**Item No.**                      **Report of the Head of Development Management and Building Control**

**Address:**                      11-17 VICTORIA ROAD RUISLIP MANOR

**Development:**                Erection of ground floor rear extension and three storey extension above existing commercial parade to provide 7 residential units (Class C3) (2 x 1-bed, 2 person units, 4 x 2-bed, 3 person units and 1 x 3-bed, 5 person unit)

**LBH Ref Nos:**                **72104/APP/2025/1096**

Proposed Ground Floor Plan
Scale 1:100

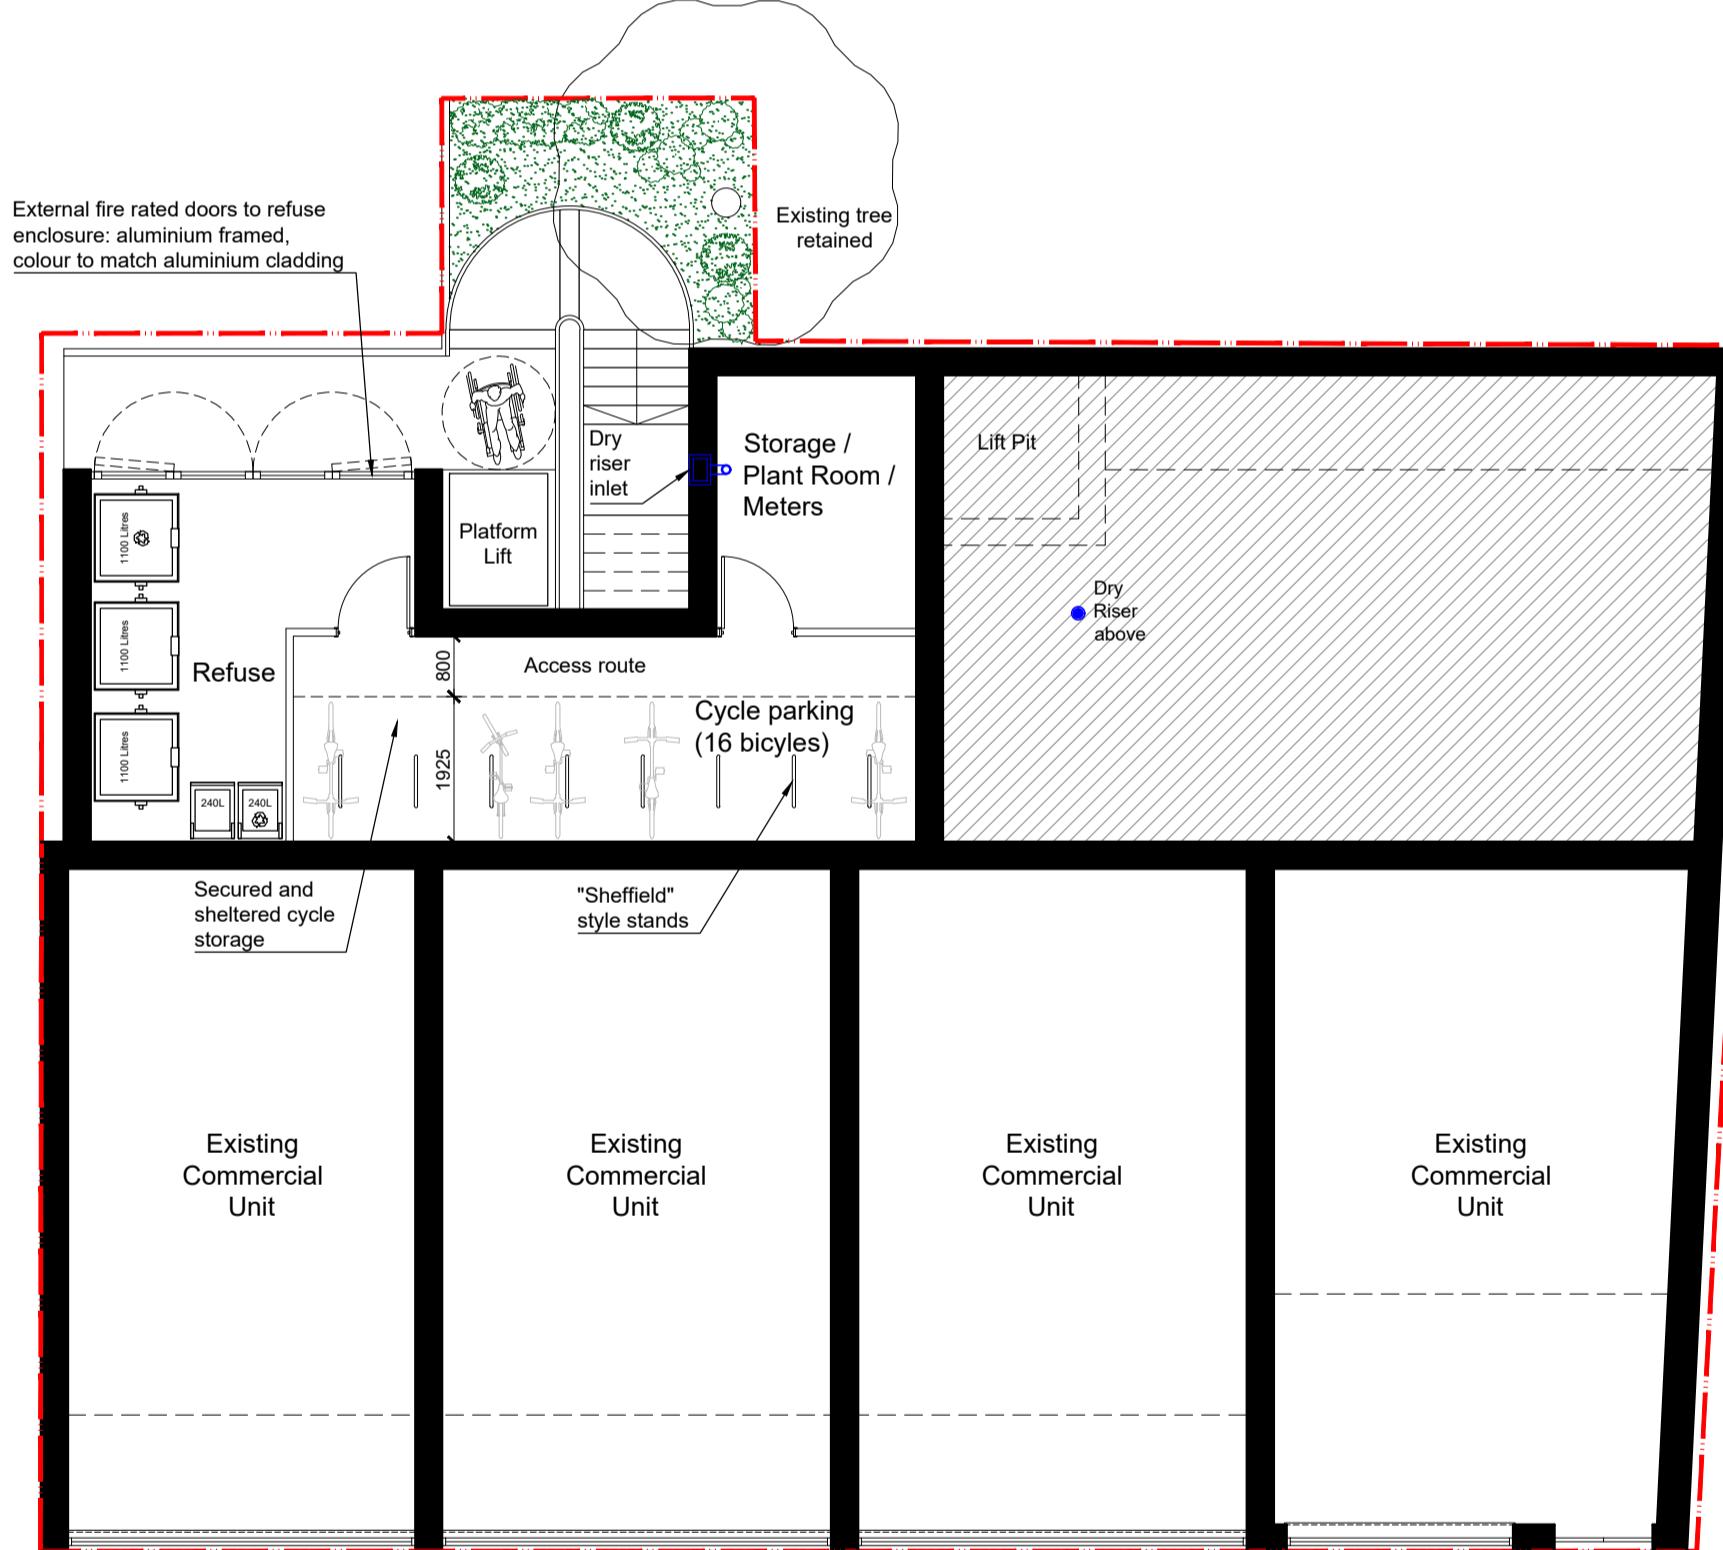
The proposed access arrangement to the residential development, located to the rear of the existing street frontage, is considered unacceptable due to concerns relating to the safety and security of future occupants. The access route lacks appropriate levels of natural surveillance and fails to provide a clearly defined, well-lit, and secure approach to the residential units. This creates an environment that may foster crime and antisocial behaviour, to the detriment of residential amenity and community safety. The proposal therefore fails to comply with the principles of "Secured by Design" and is contrary to Policy D11 of the London Plan (2021), Policy DMHB 11 of the Hillingdon Local Plan: Part Two - Development Management Policies (2020), and the guidance set out in the National Planning Policy Framework (2024).

Significant concerns are raised in relation to the proposed access to the new residential units being from the rear of the site rather than Victoria Road. The current rear of the building has the character of a service yard, being dominated by parking and business such as the neighbouring motorbike and car tyre businesses, meaning it would not be a safe or attractive route for pedestrians. It is recommended that the scheme is changed to create a new residential access from Victoria Road, which would be far more legible, safe and functional. This would require the loss of a relatively small area of commercial floorspace, but there would still be sufficient space for commercial units. The proposed units are in accordance with NDSS in terms of their size, but two of the units are not dual aspect as defined in Appendix 3 of the Mayor of London Housing Design Standards LPG, as they only have a very short side return elevation, raising issues around overheating and a lack of through ventilation. Flat 5 also lacks external amenity space as required by planning policy.

Proposed Rear Elevation
Scale 1:100

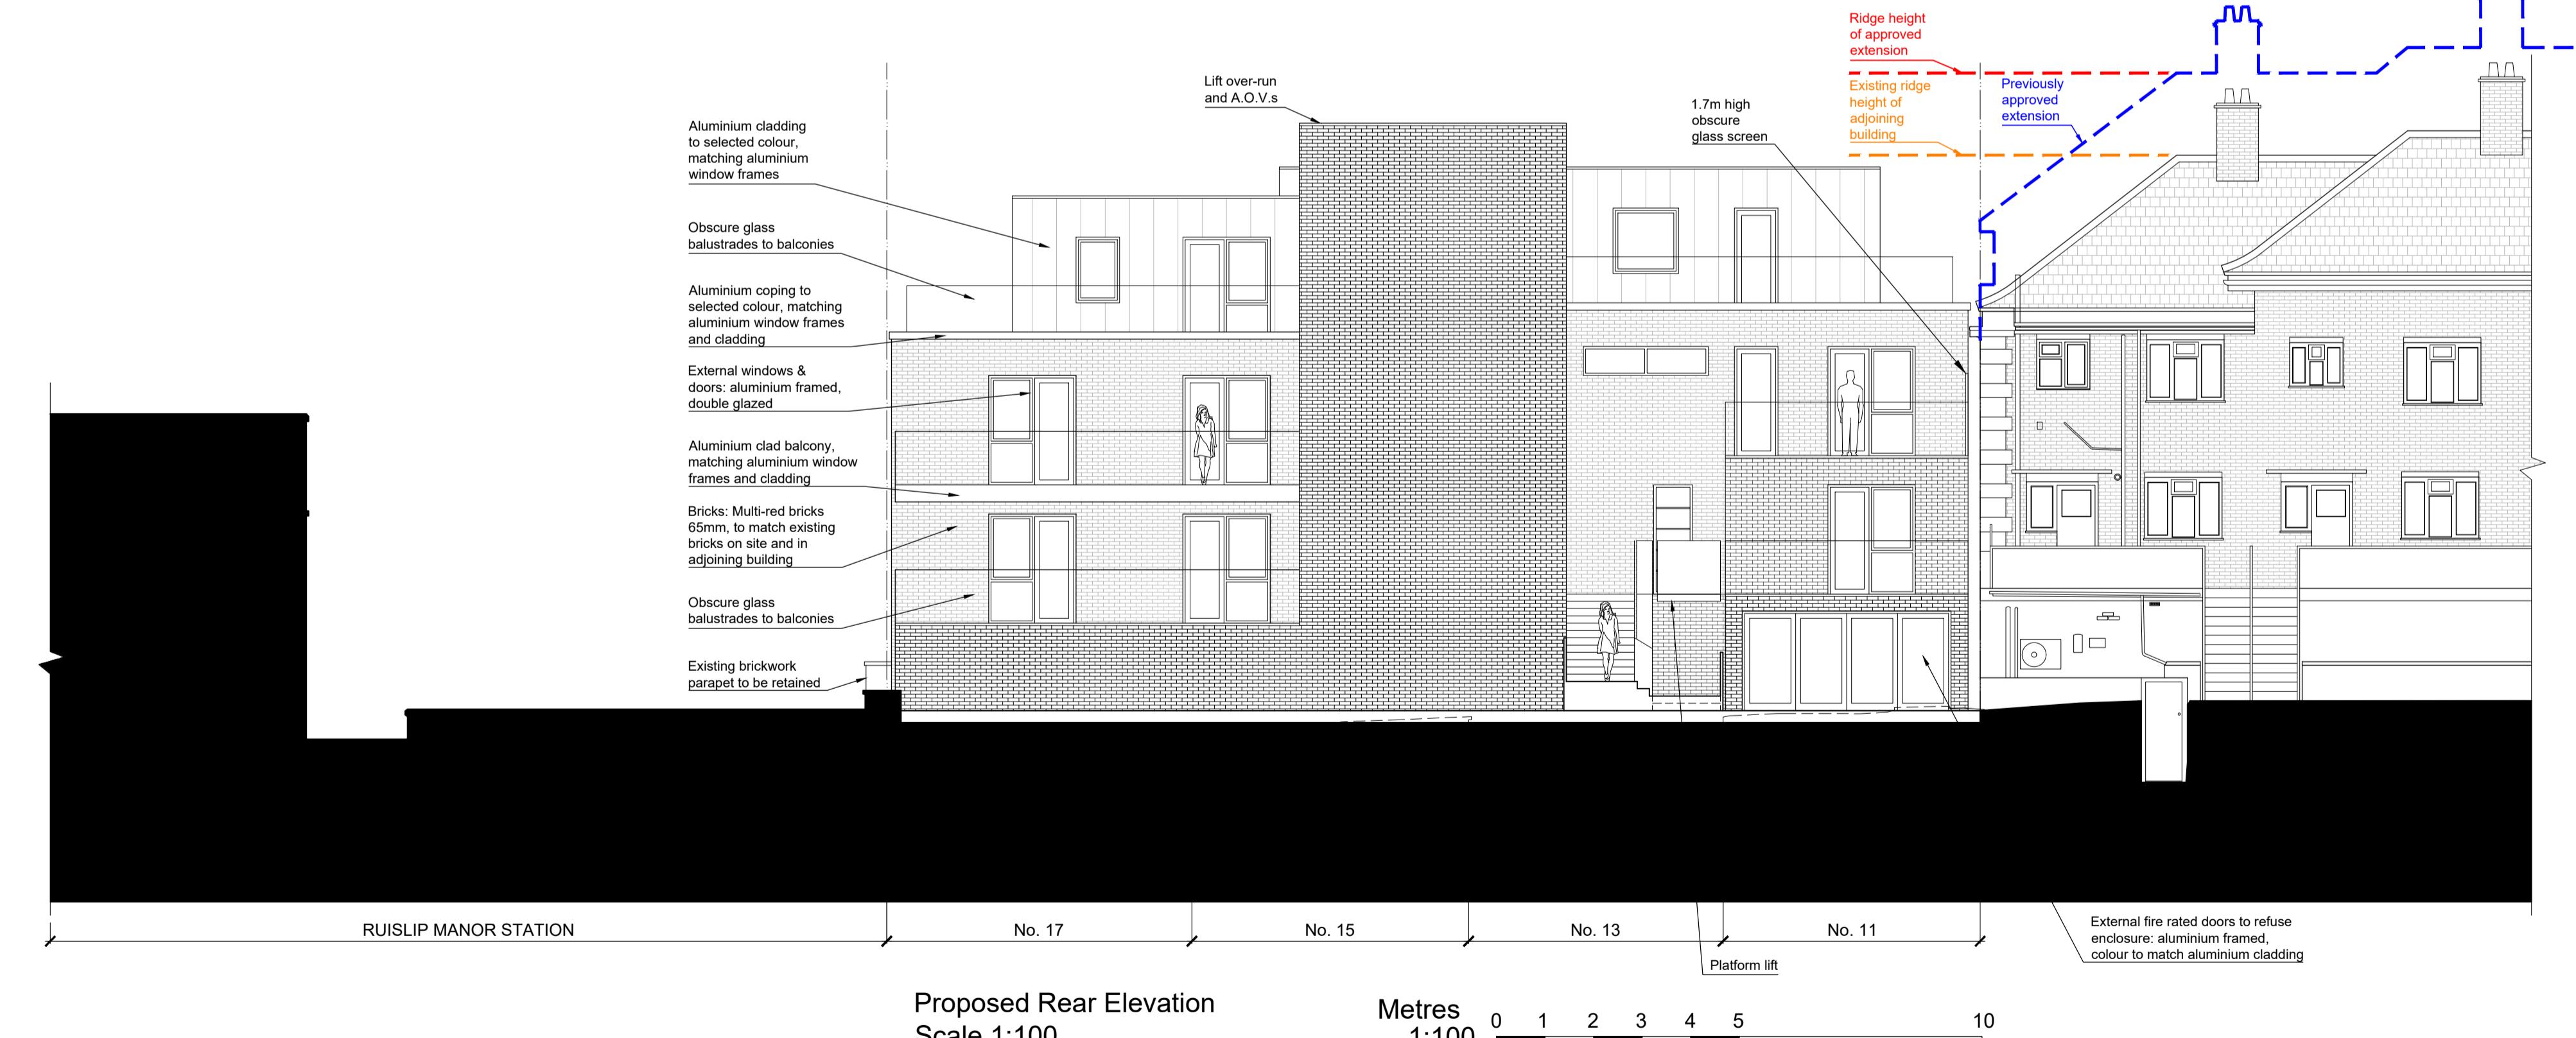
The amenity space proposed within the scheme is in the form of external balconies and terraces with glazed balustrades. These elements are considered incongruous to the existing building and its context. Victoria Road is a busy road so the provision of the first floor terraces is not supported as it is considered that in this form, the amenity space is less likely to be used. Inset balconies are considered to work better in this current context providing better screening from traffic, noise and pollution.
